With regards to the above application I would like to ask you for your confirmation of an EoT with a new deadline on 26 June 2020.

Meanwhile, I do not know if you had a chance to see the comments of our Drainage Engineers:

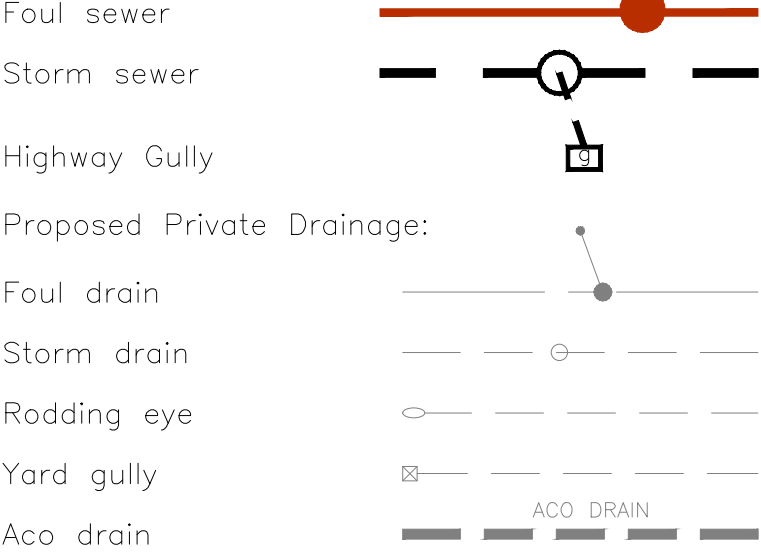
- a) The open channel/ditch in which the sewage treatment plant discharges into at present, before it connects into the suds pond, is proposed to be infilled.
The applicant will need to be provide written confirmation with supporting calculations to prove that the storage for surface water within the suds system is not compromised as a result.
- b) Where the proposed rising crosses the incoming surface water outfall to the pond and the known land drain running parallel to the eastern boundary of the development, the applicant should provide a longitudinal section to prove no impact on these pipelines.
